Date 8 February 2022  
Our Ref 22/00084/CLP

**Town and Country Planning Act 1990 (As Amended)  
31 Nonsuch Walk, Cheam, Sutton  
Single storey rear extension (Application for Certificate of Lawful Development for  
Proposed development).**

Existing Ground Floor Plan 1-100 @ A3

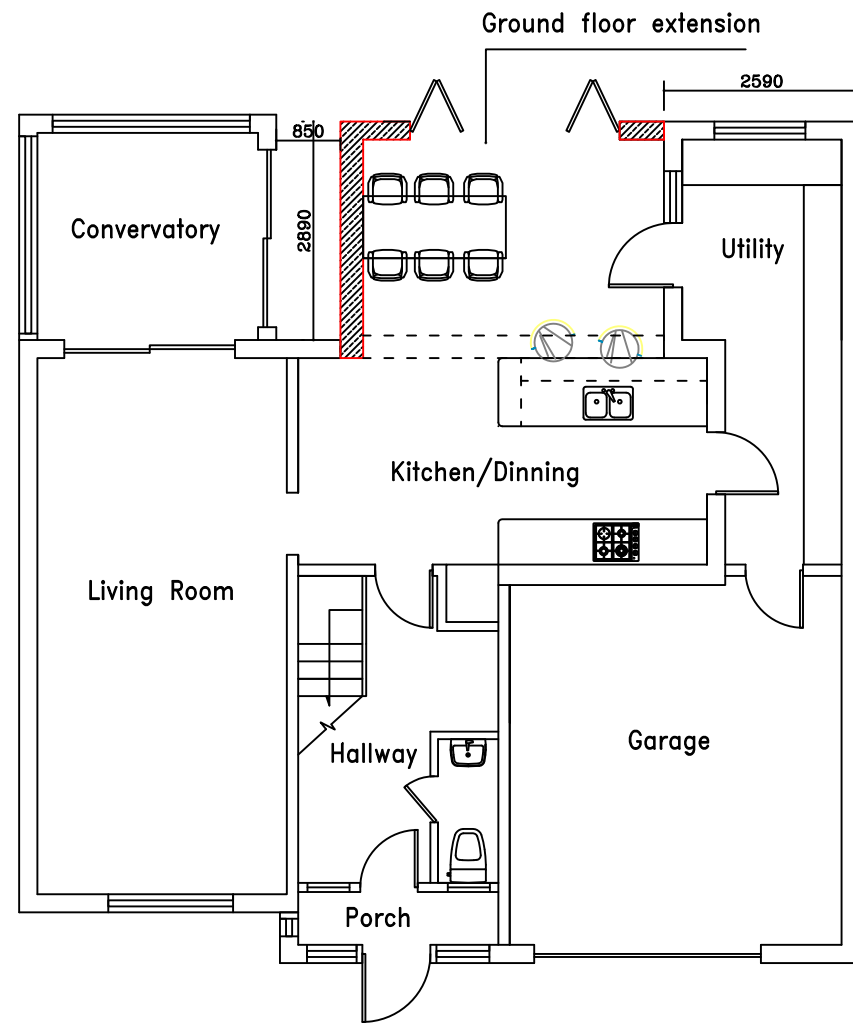
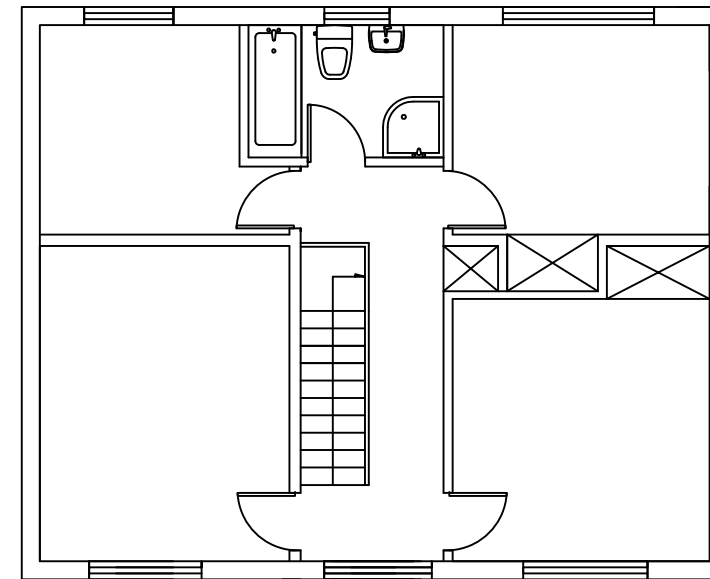
1 Please provide correctly label plans. You have label proposed floor plans incorrectly as existing and you also label existing elevation plans as proposed.
